This is a response to the "Consultation" by NH on the changes to submitted DCO for the A66NTP Scheme as follows on behalf of the BRITISH HORSE SOCIETY for NORTH YORKSHIRE SECTION - Stephen Bank to Carkin Moor

1. DC-29 " Realignment of A66 mainline and Collier Lane

2. DC-32 " Lower the A66 mainline levels east of Carkin Moor and change an underpass to an overbridge

COLLIER LANE - WORK NO. 09-5
LONGITUDINAL SECTION - CHAINAGE 000 - 189

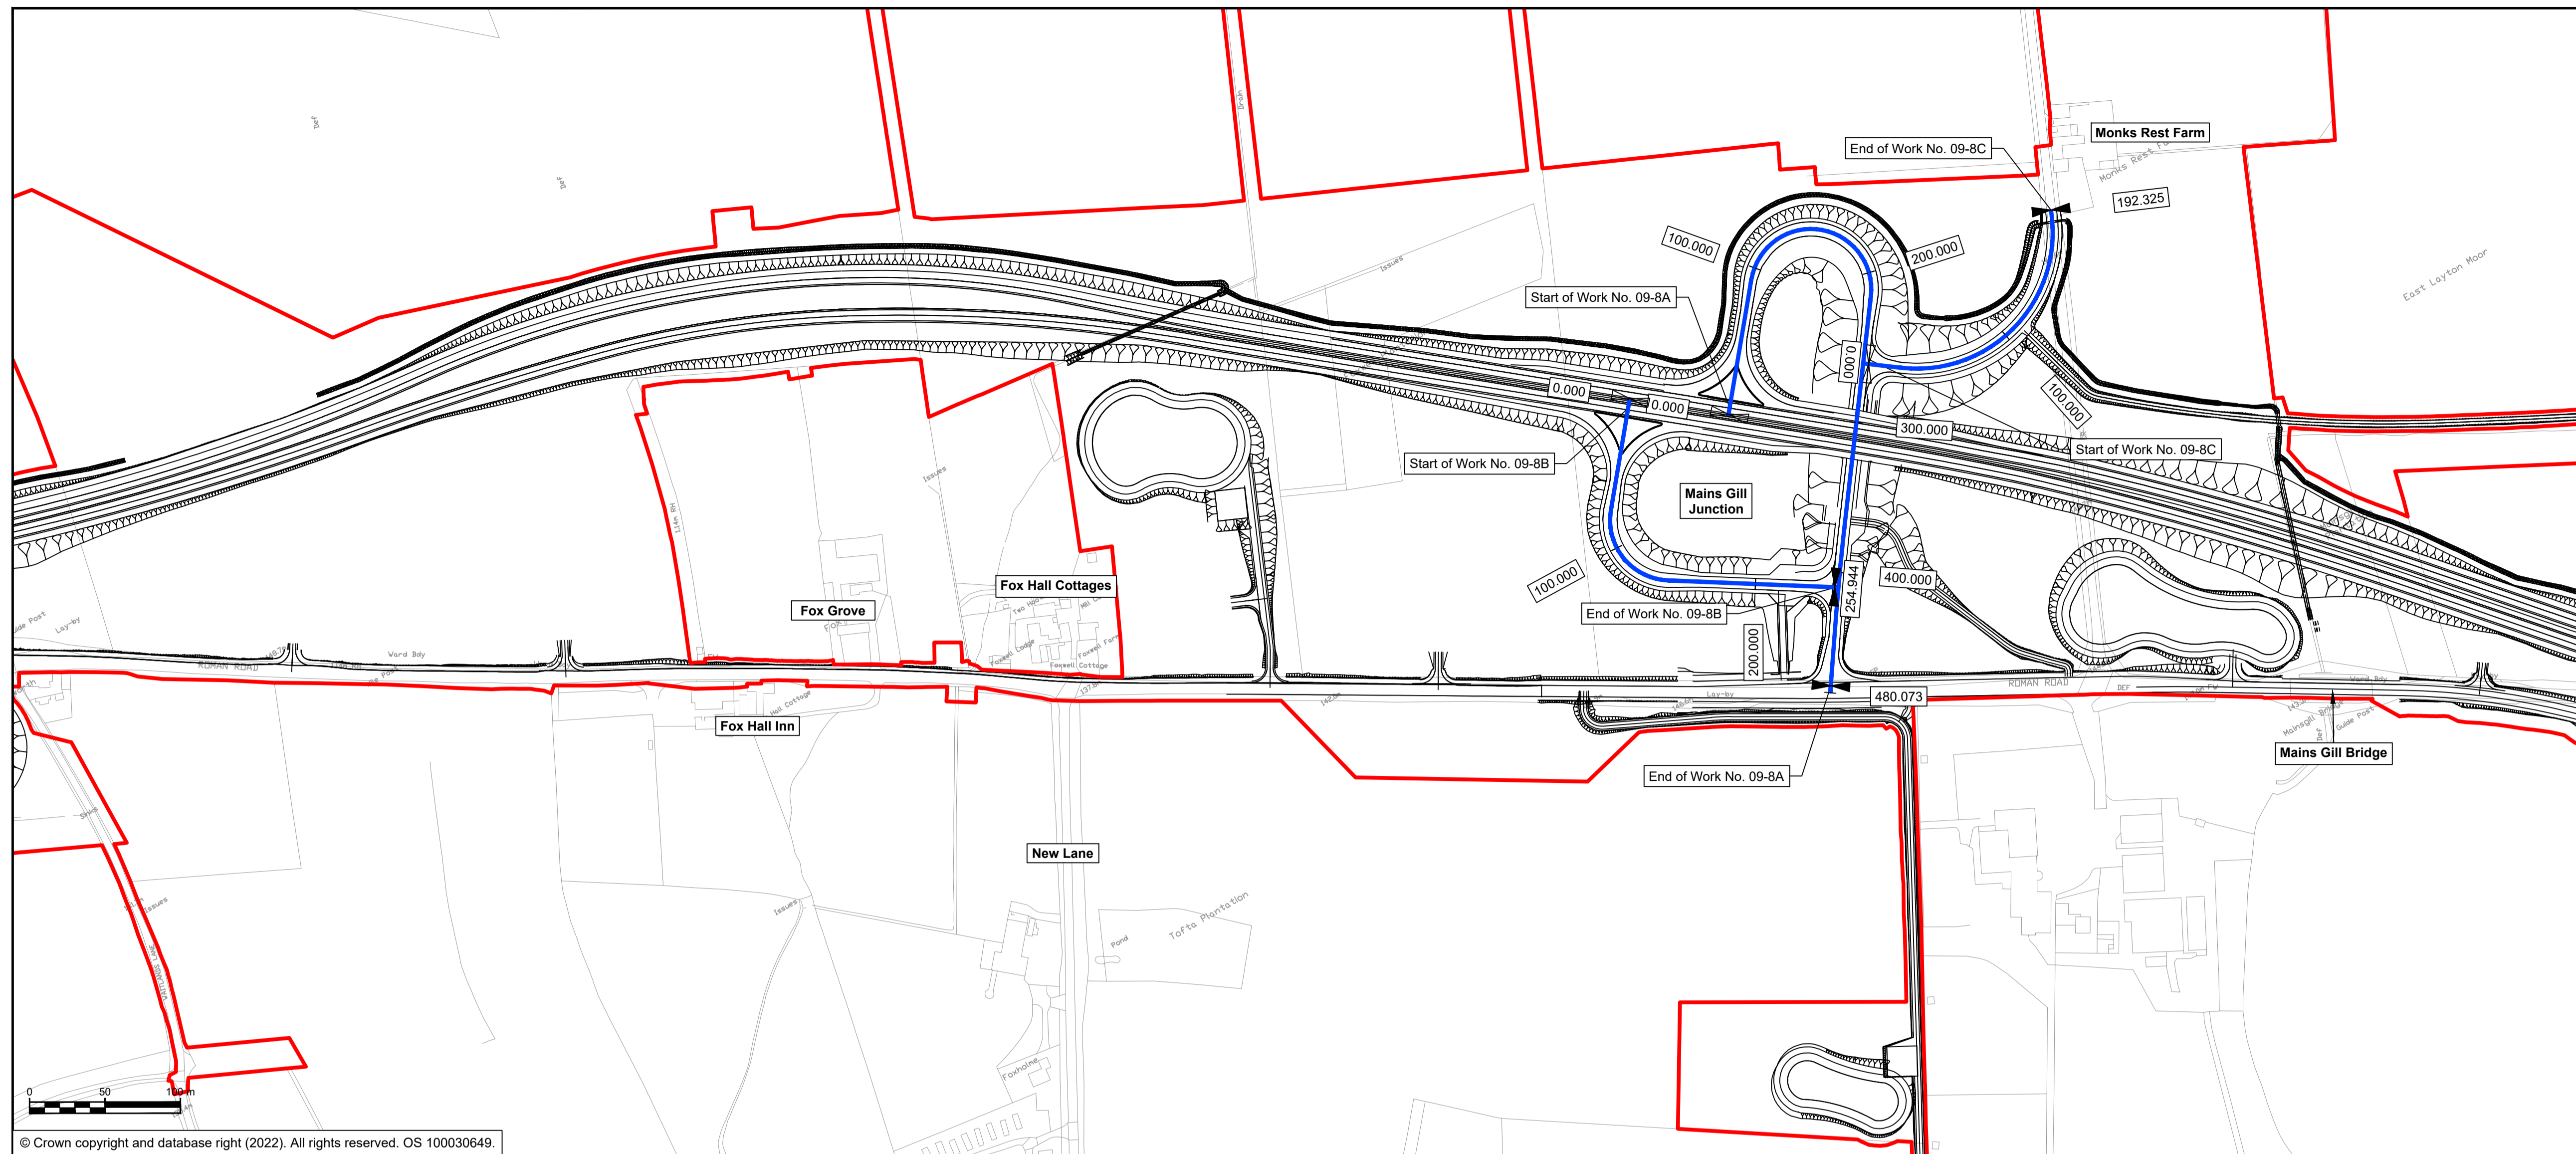
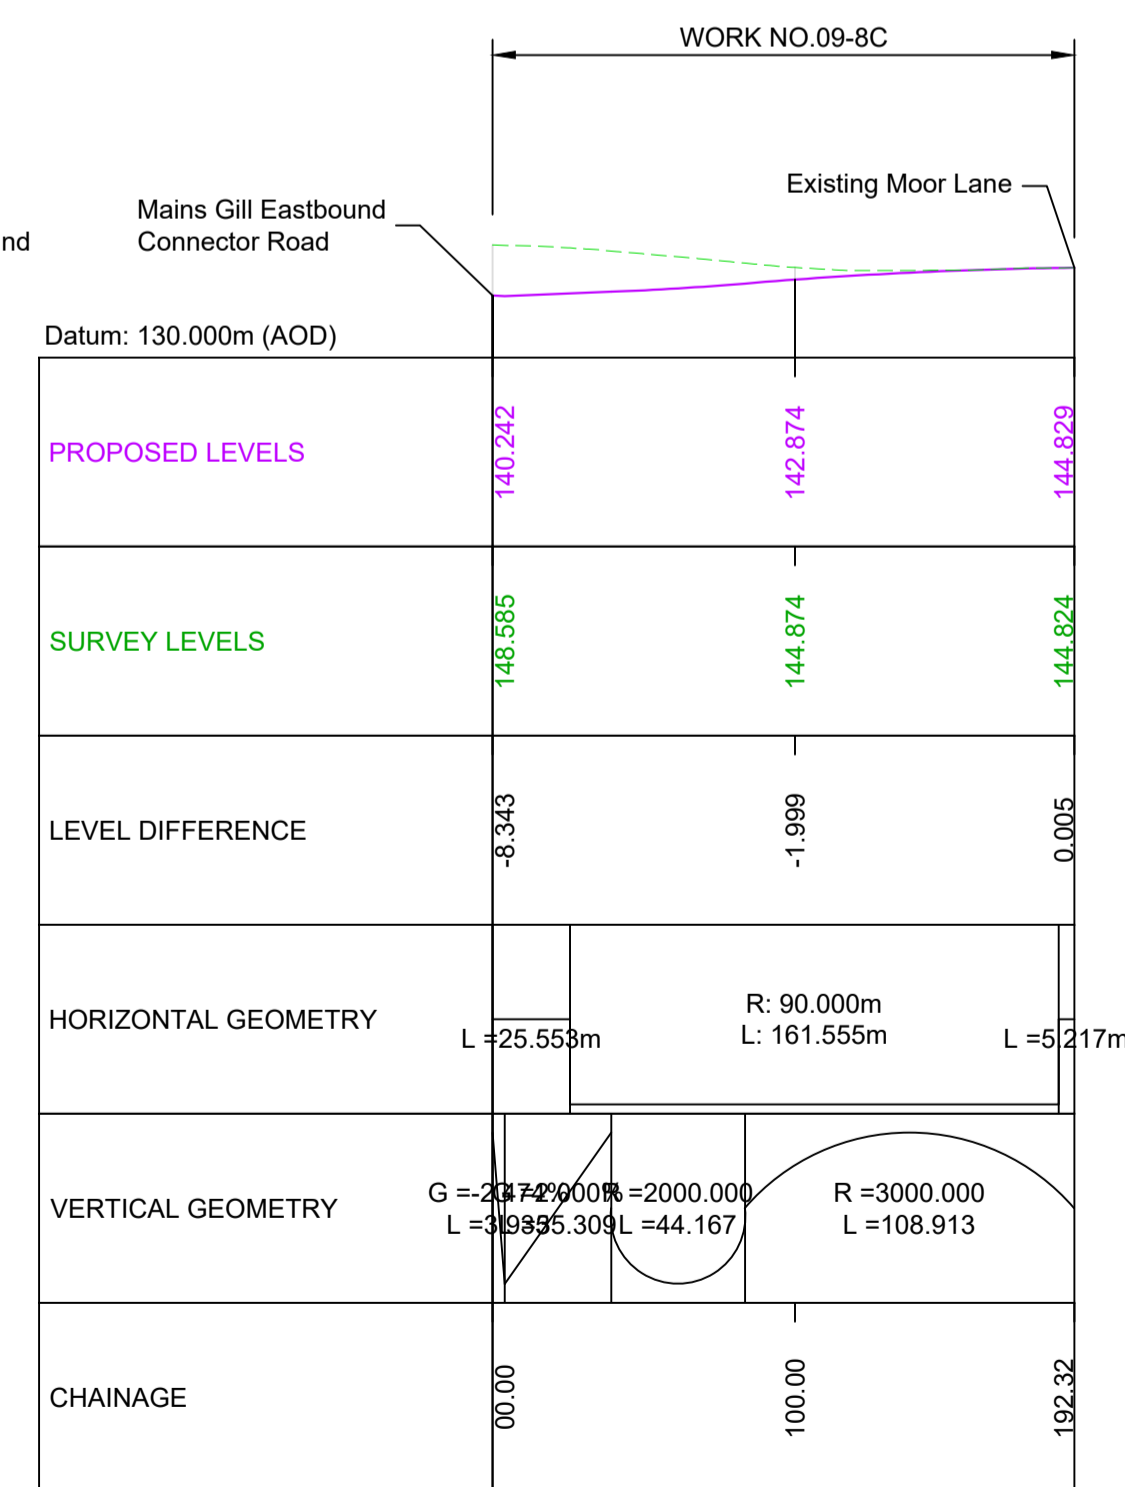
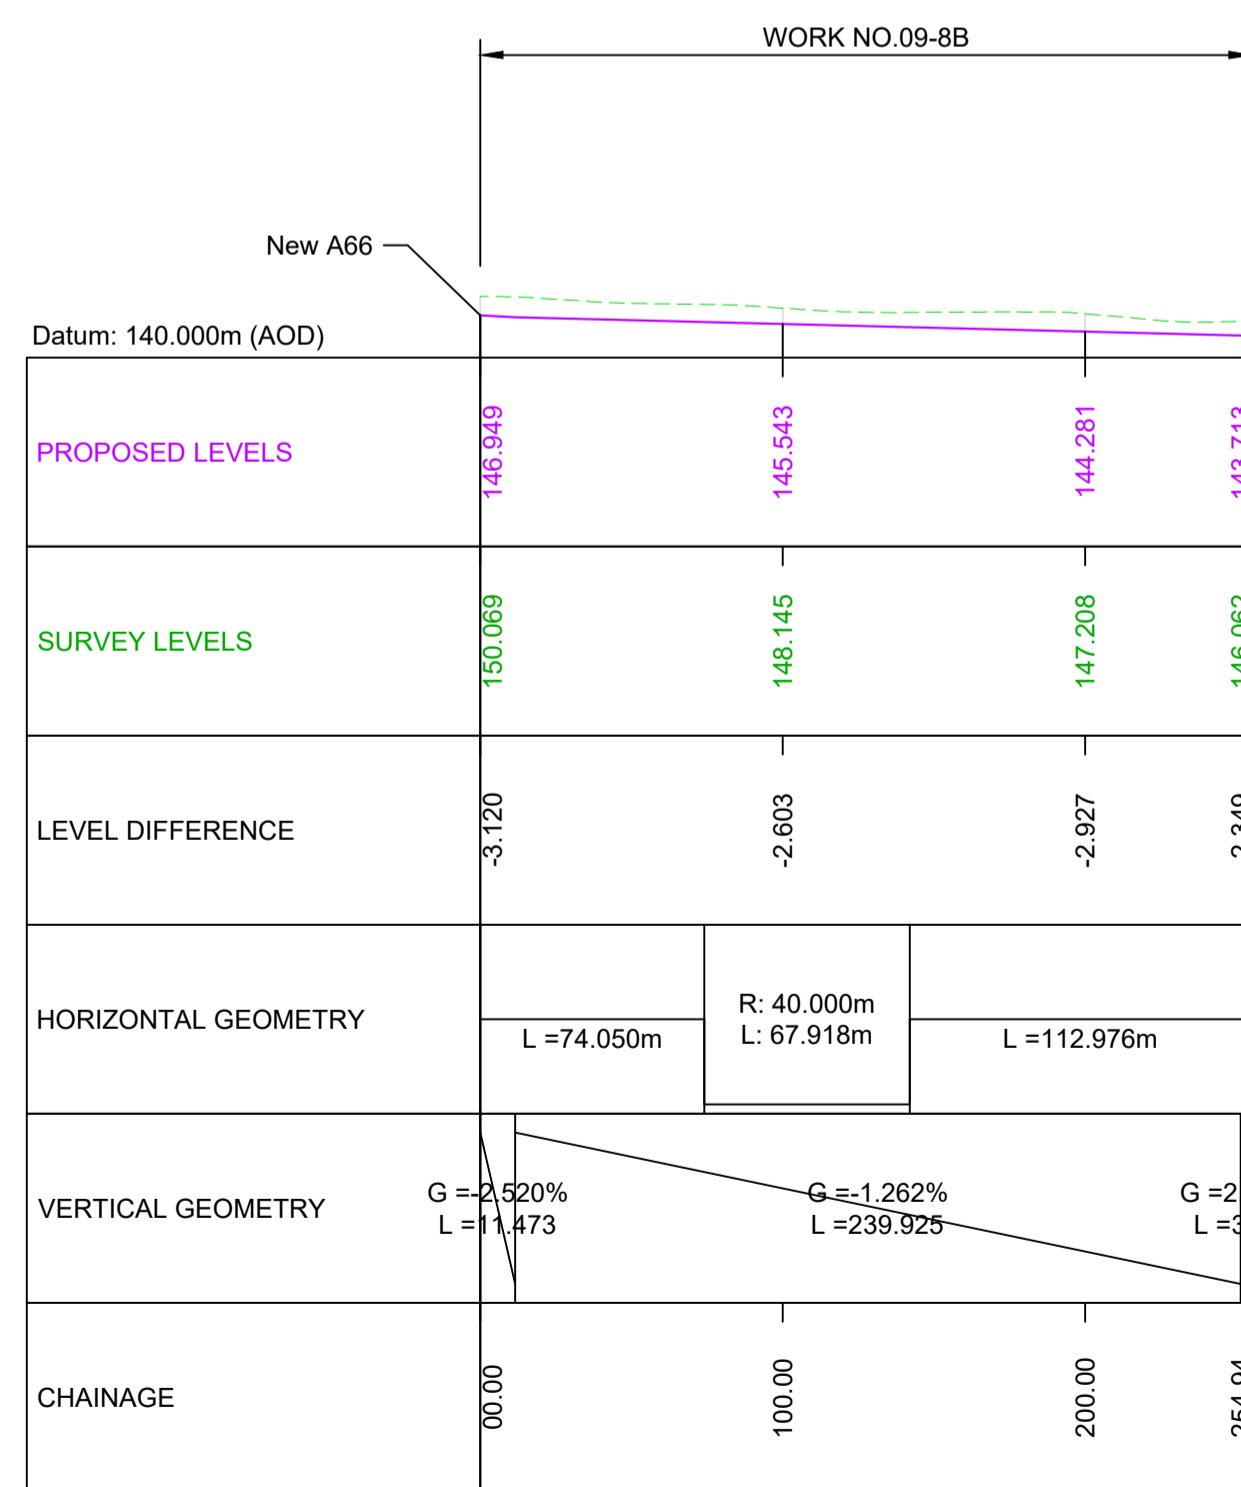
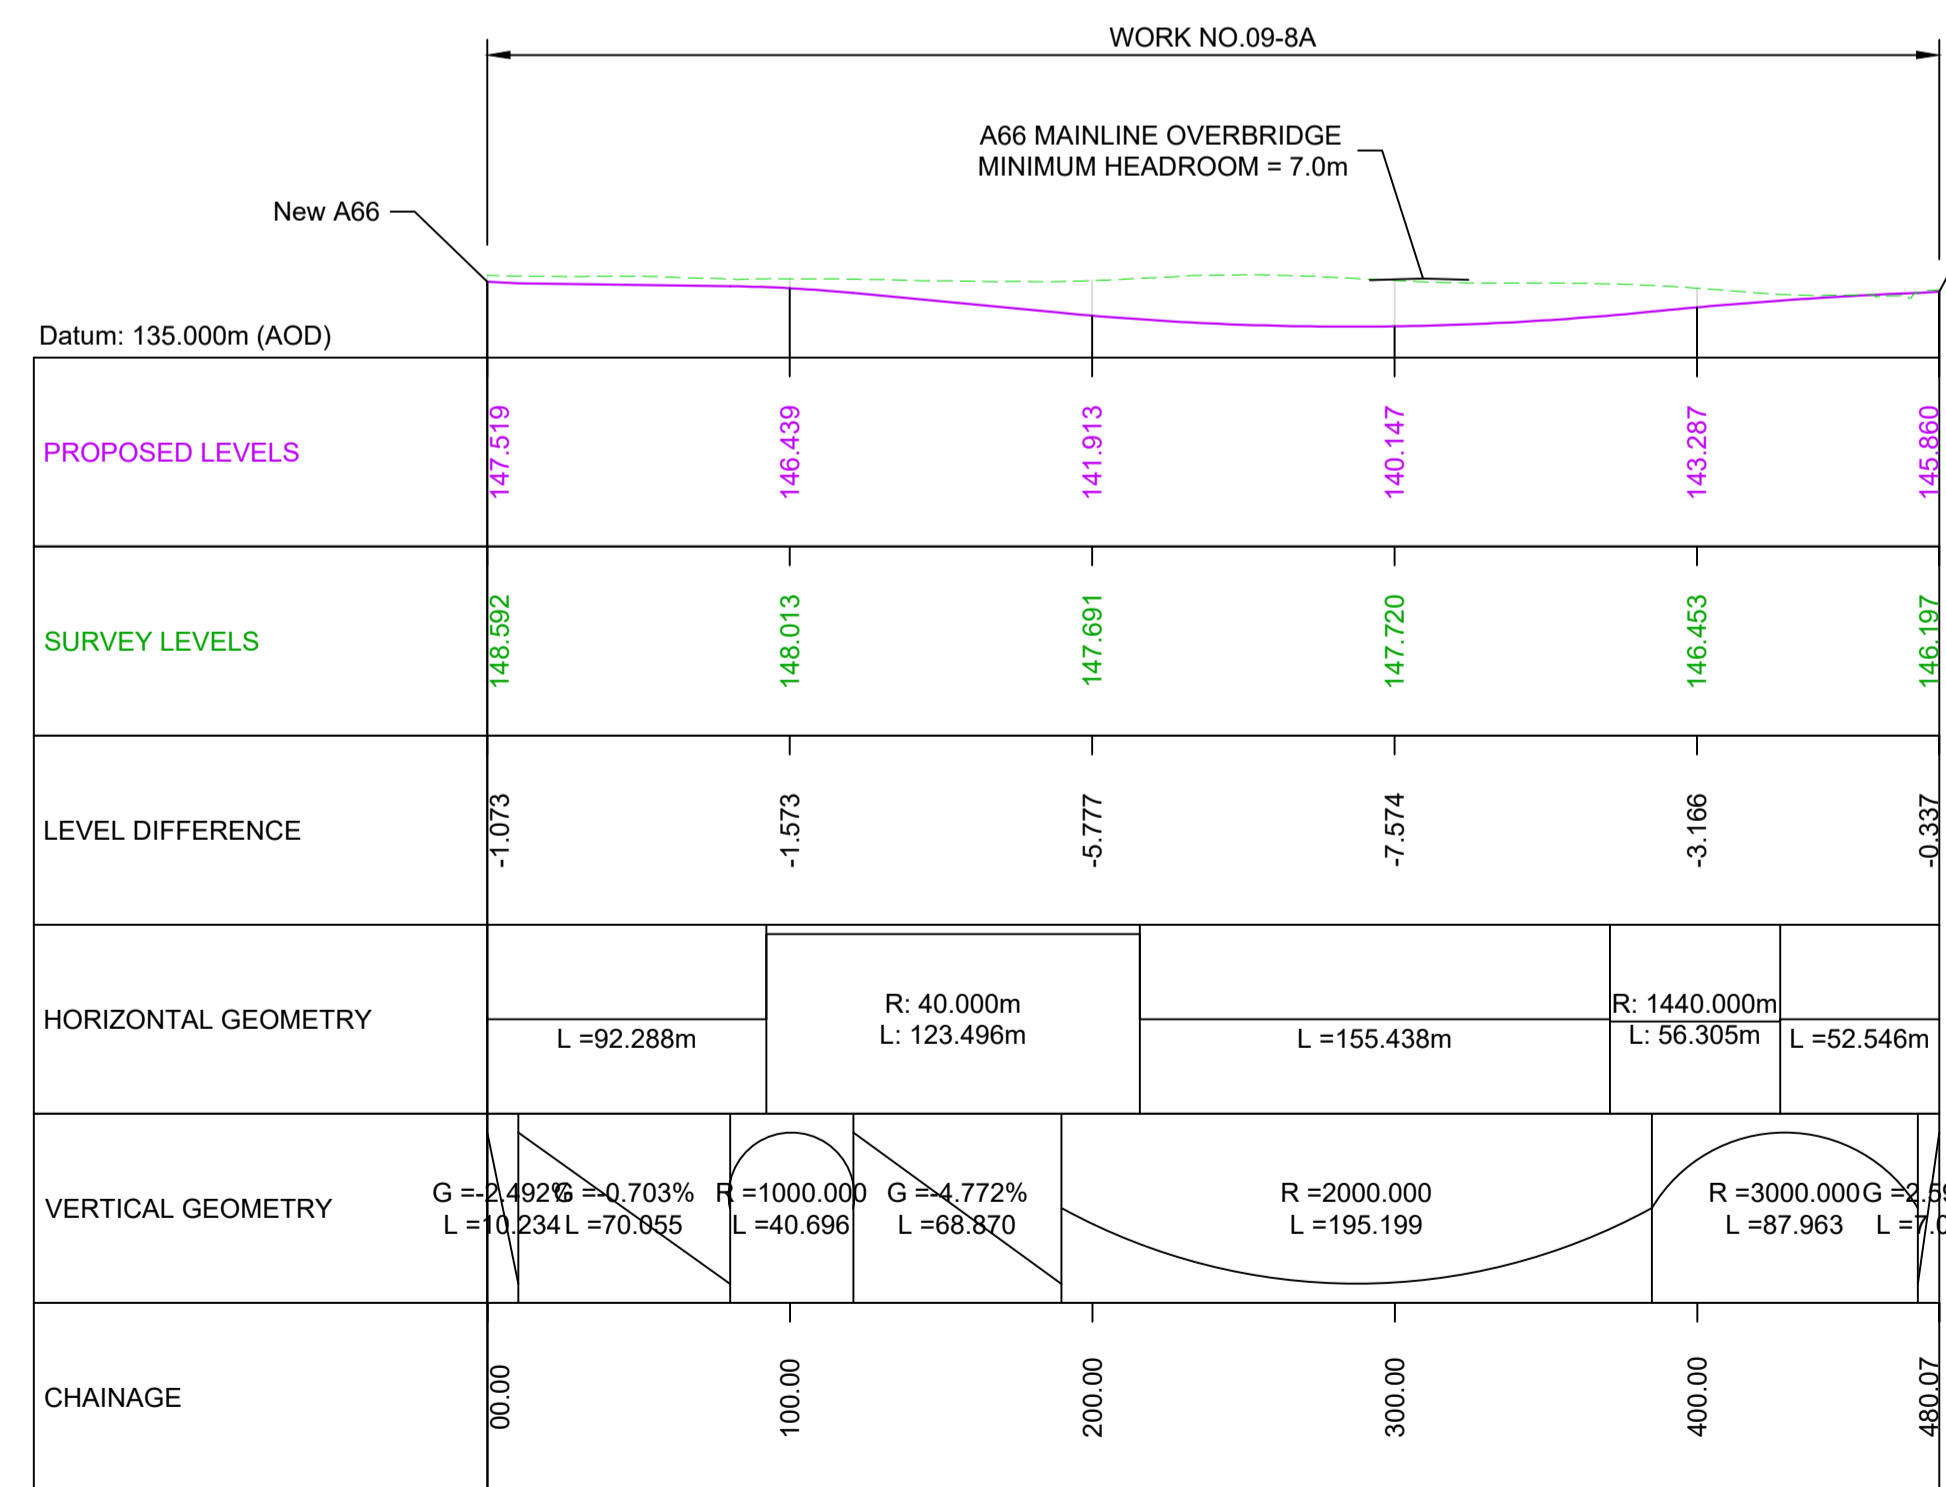
This change is not acceptable to the British Horse Society as it will involve a lengthy diversion an additional 0.96km on top of 0.5km making a total of 1.46 km just to get to the Collier Lane overbridge, on an unpleasant route shoved up against the A66 Motorway. Then it will be necessary to cross the overbridge with the vehicular traffic before a return ride back along the de-trunked A66 "Local Access Road" next to speeding traffic for 0.96km. This makes the total diversion close 1.85 km, nearly twice the 1 km in the DMRB and is a longer diversion than is acceptable.

Riding close to the LAR puts horse riders at risk as the road will have a 60mph speed limit, it will be a wide straight road with narrow verges and motorists will be doing 60mph or greater (from experience of the LAR on the A1M). We were assured the provision would be grade separated bridleway and PMA crossing linking the Hutton Moor Bridleway into the minor road network (Dick Scot Lane) which leads directly into a bridleway south of the A66. This does not deliver it and is an unsafe and unpleasant route.

The British Horse Society OBJECTS TO THIS CHANGE DC-29

DC-29 " Realignment of A66 mainline and Collier Lane

The BHS objects to this proposed change as the new route is substantially less convenient.
